## **SUBMISSION AS THE LOCAL PLANNING AUTHORITY**

**1.1.** The following information is submitted in response to the examinations taken place between 3<sup>rd</sup> December 2024 and 5<sup>th</sup> December (ISH1 – 5) and the information submitted at Deadline 3 by the Applicant (National Highways) for the A46 Newark Bypass for an Order granting Development Consent. Our comments follow the Council’s Local Impact Report (REP1-035), Written Representations (REP2-051), response to ExQ1 (REP2-050) and comments on Deadline 2 submission documents (REP3-046), namely the Historic Environment and Visual Impact Assessment (REP2-020).

**1.2.** The comments made for Deadline 4 are made by Newark and Sherwood District Council in their statutory role as the Local Planning Authority (LPA) and not as landowner. Where comments are made as the landowner these are clearly defined in a separate section for the ExA to see.

**Viewpoint 24: View north from Sandhills Park representative of views for residents.**

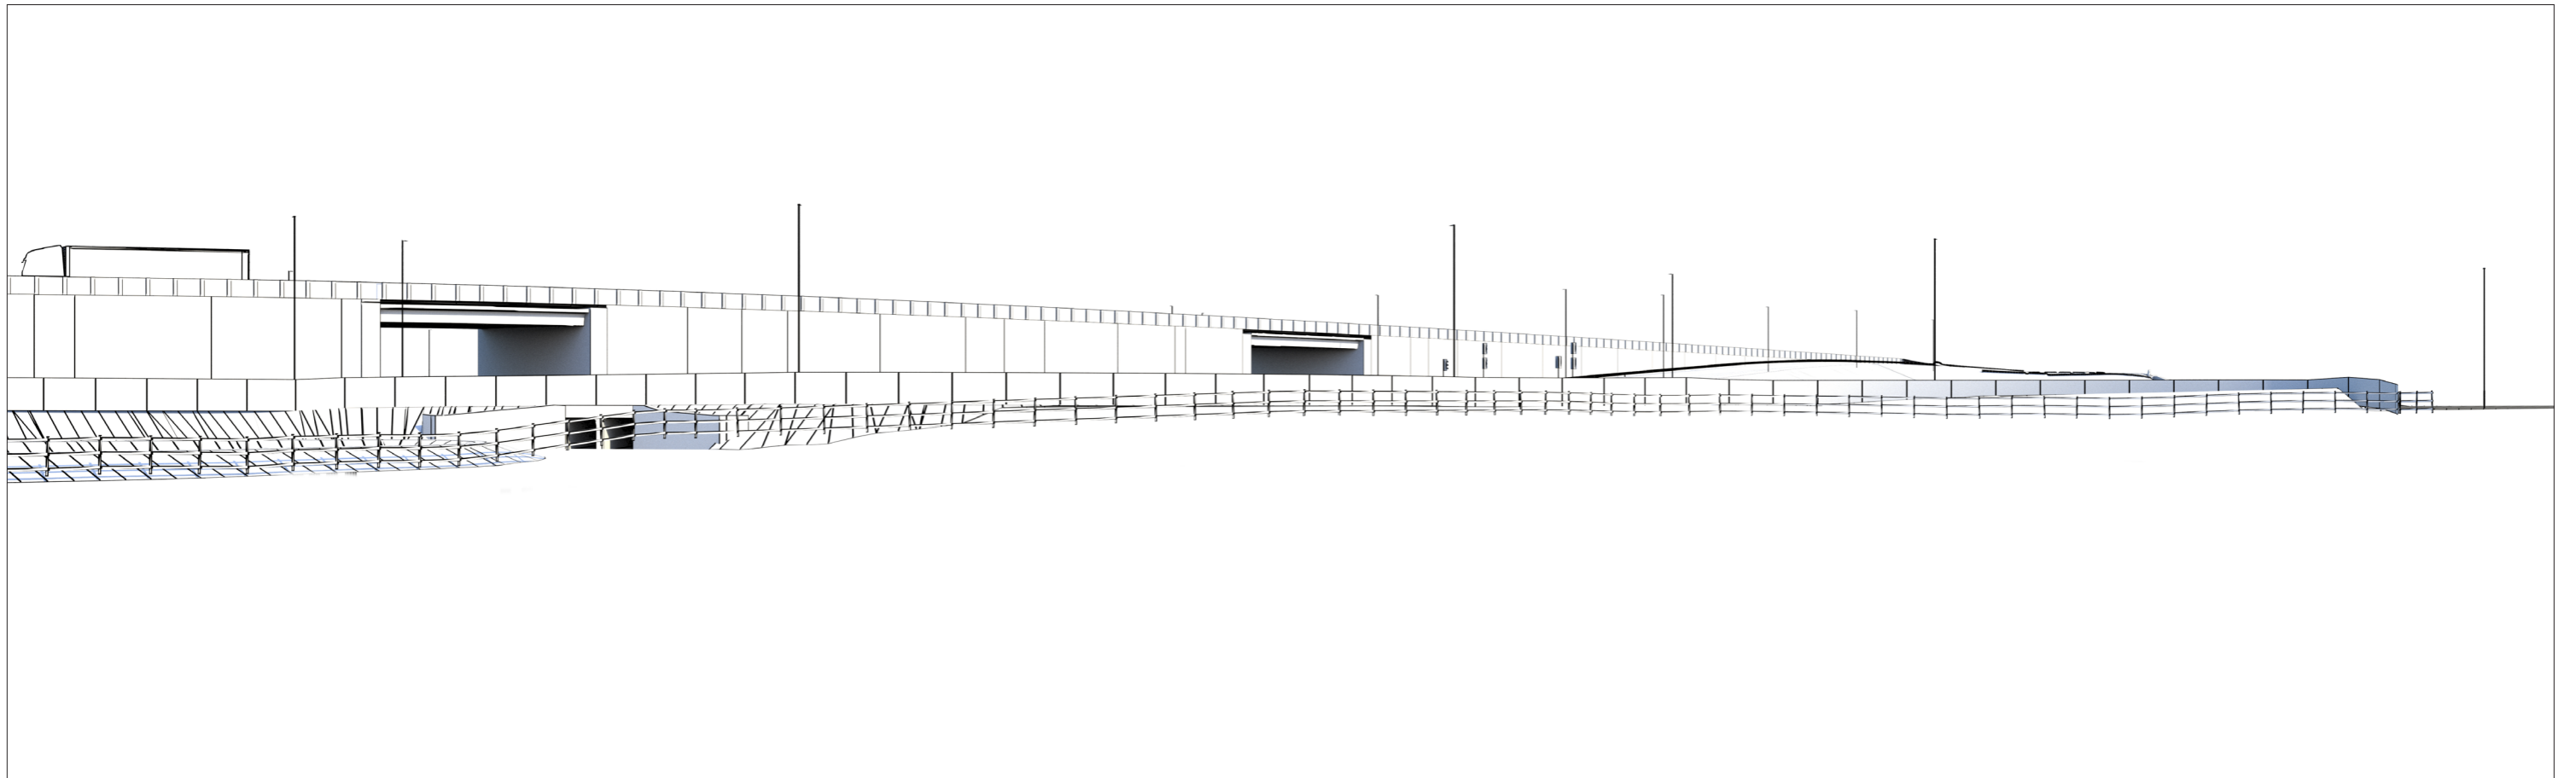
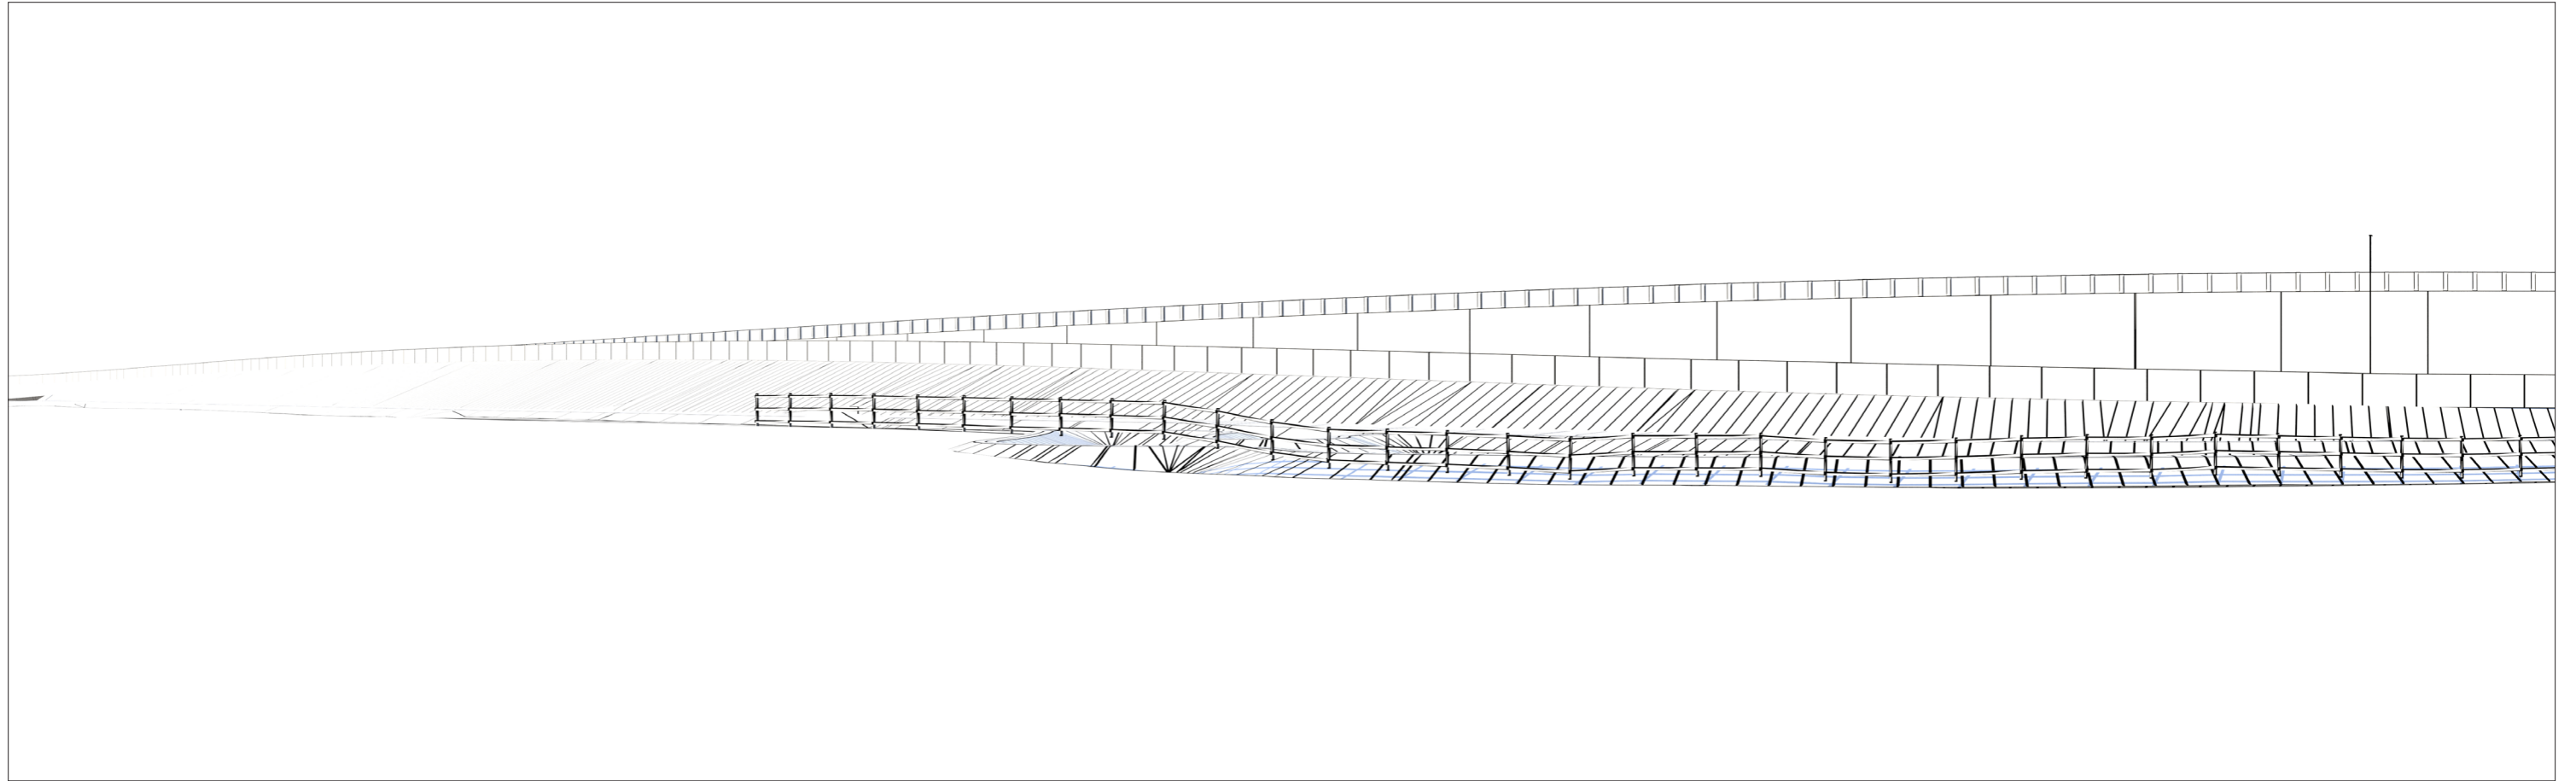
**2.27. Item 4b) Viewpoint 24 Sandhills Park (REP2-020)** – The Council does not consider that the visual representation is sufficient to represent how those residents of Sandhills Park would experience the levels change from the Cattle Market flyover. Given the intervening buildings on the plan it was suggested that a view from the A617 could show the full extent of the impact for those residents, without having to enter residents gardens or properties if this was not possible. Comments on this have been submitted by the Council as REP3-046.

**Viewpoint 25: View south from Great North Road (A616) representative of views for road users**

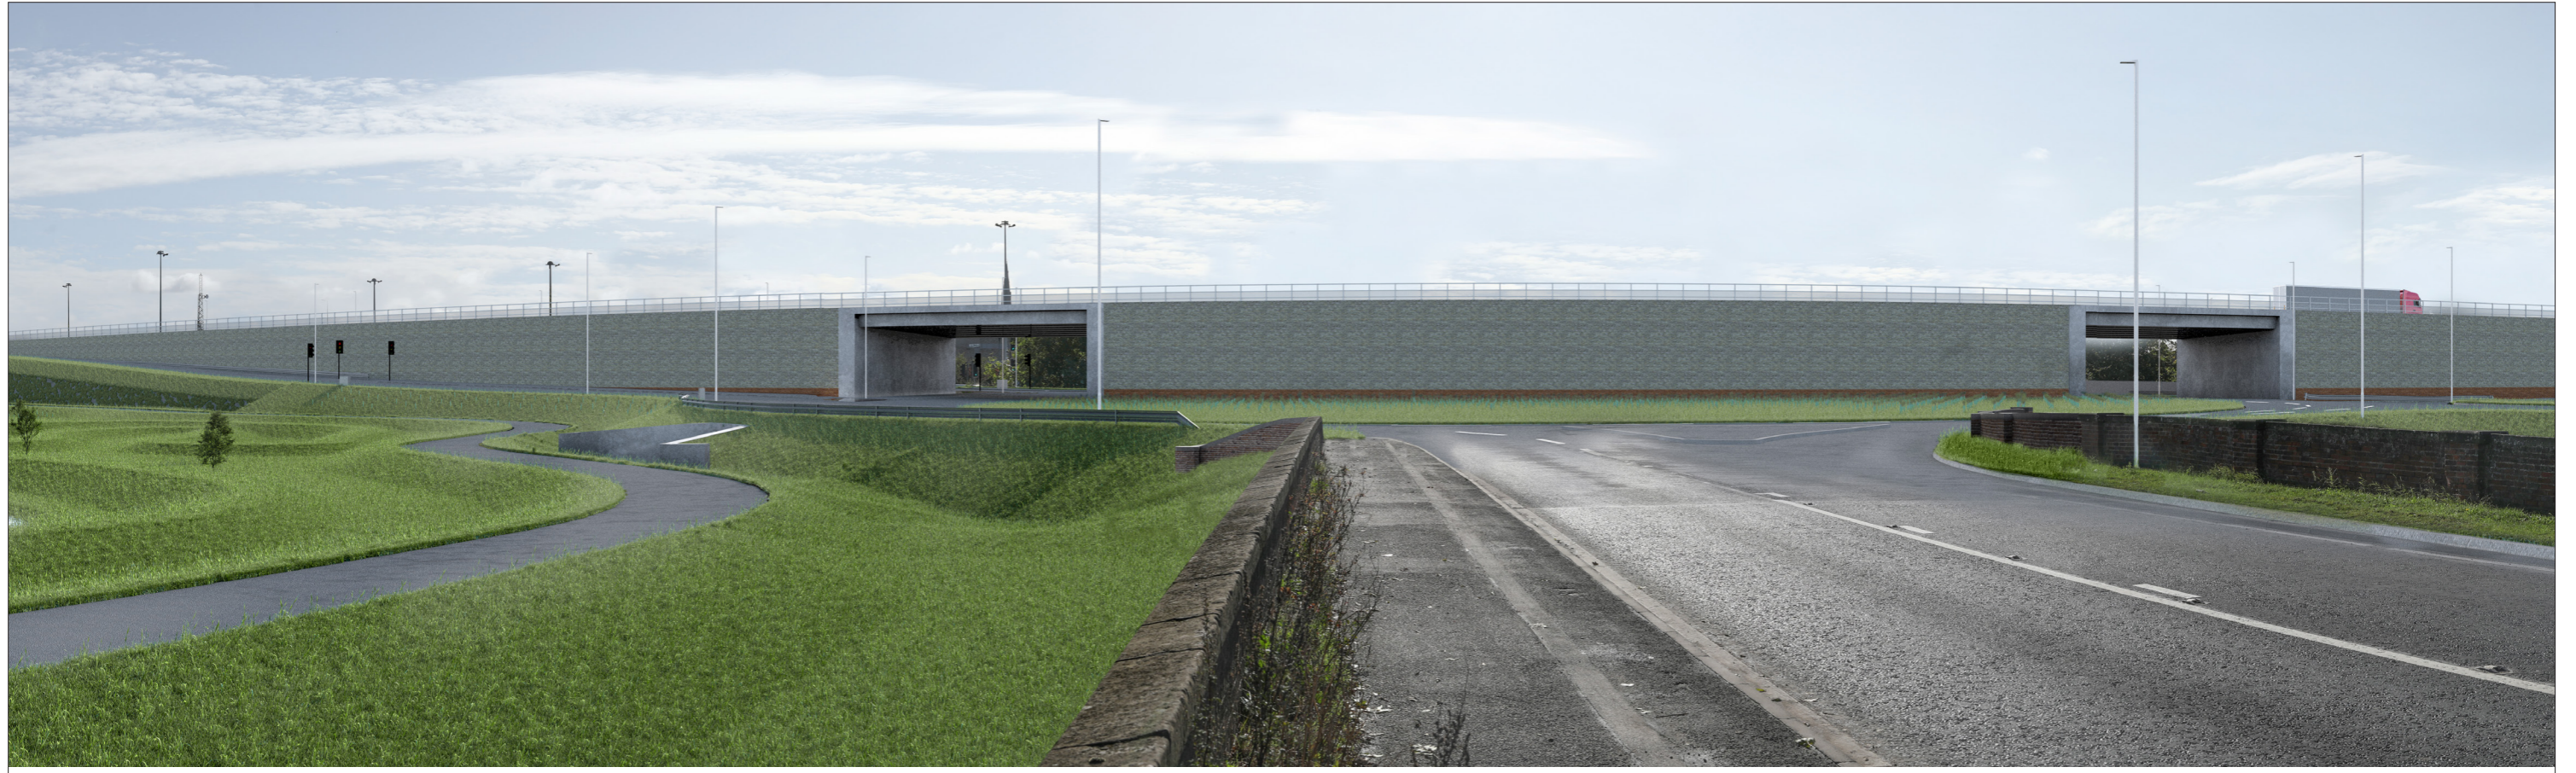
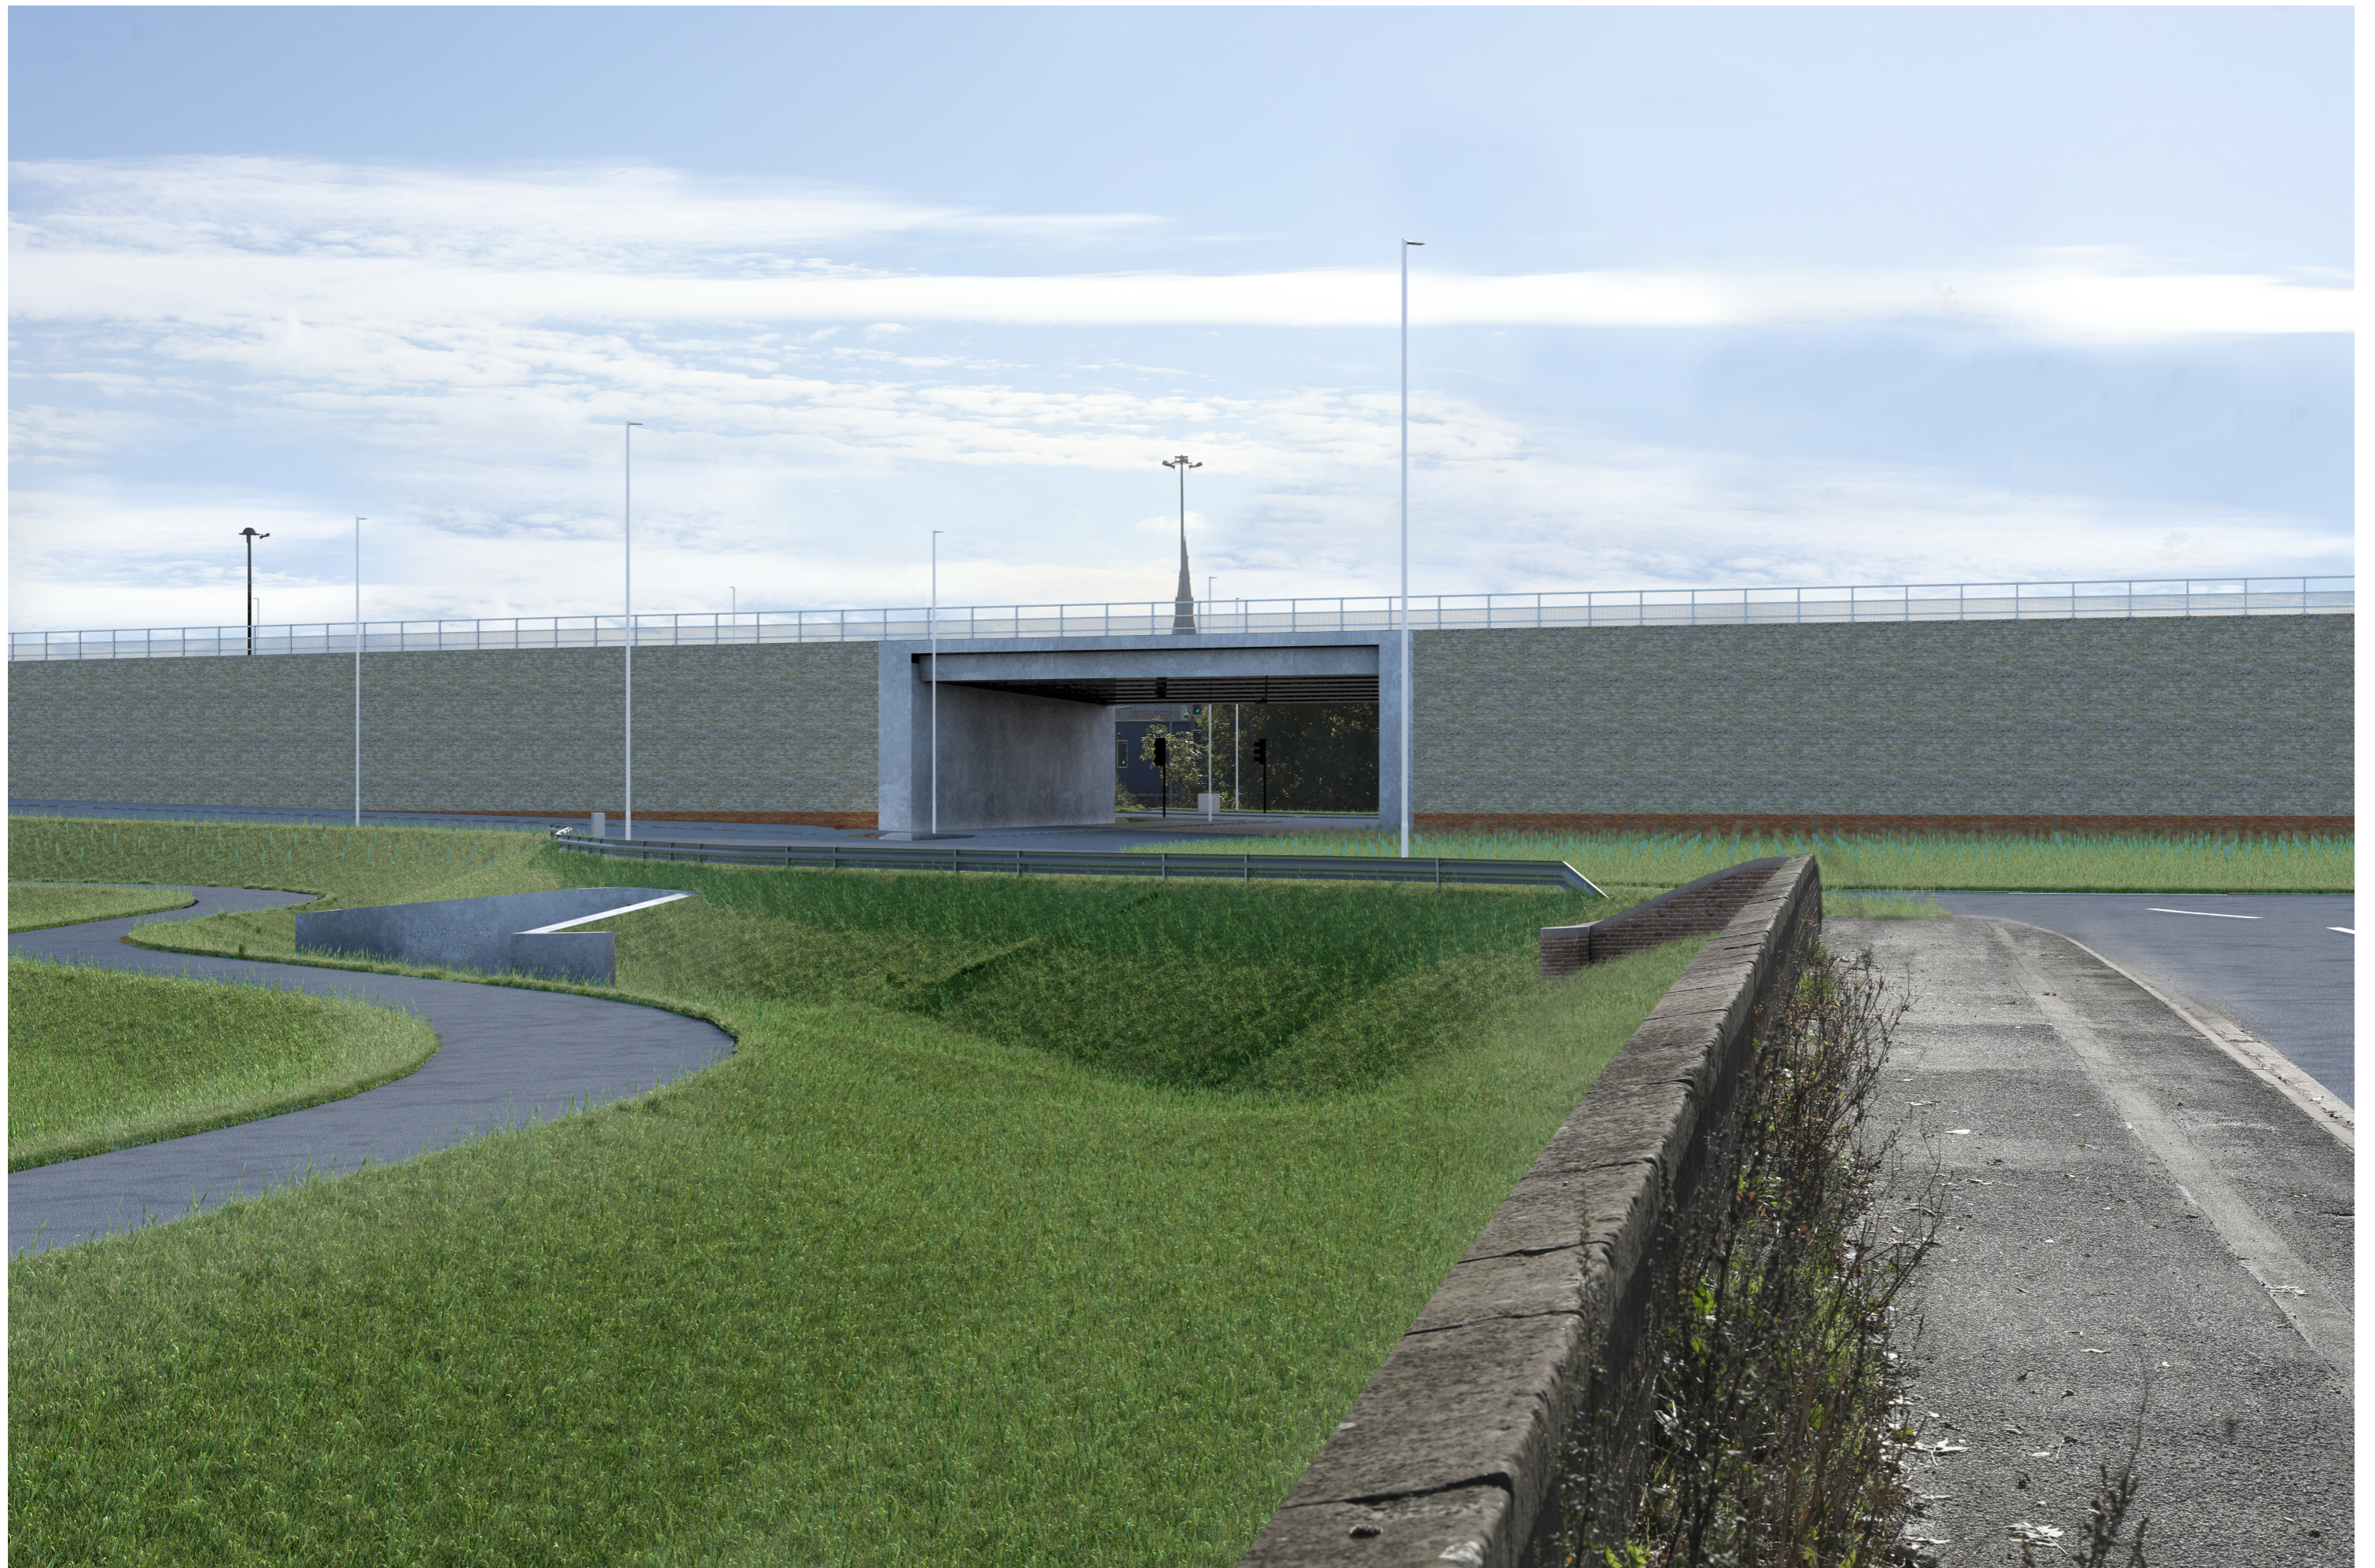
create an elevated flyover would see the landscape dominated by it without sufficient landscape mitigation as a result. (REP2-020) VP25 currently has a framed view towards the junction with vegetation on either side. At Year 1 (VP25) the vegetation has been removed and at year 15 there is not a lot of difference. With reference to BNG and the direct reference to NCA46 (National Landscape Character) and Section 4.2 which makes direct reference to boundary features within this landscape area and in particular wet willow boundary features. The existing baseline shows the framing of the approach and the character of moving along the A616 is fairly consistent in that there is a mature boundary treatment for some distance on a straight road with long distant views. However where there has been a loss of that vegetation the Council would like to see some confidence that that vegetation can reestablish again overtime and we feel that looking at that baseline position it seems a rational position.
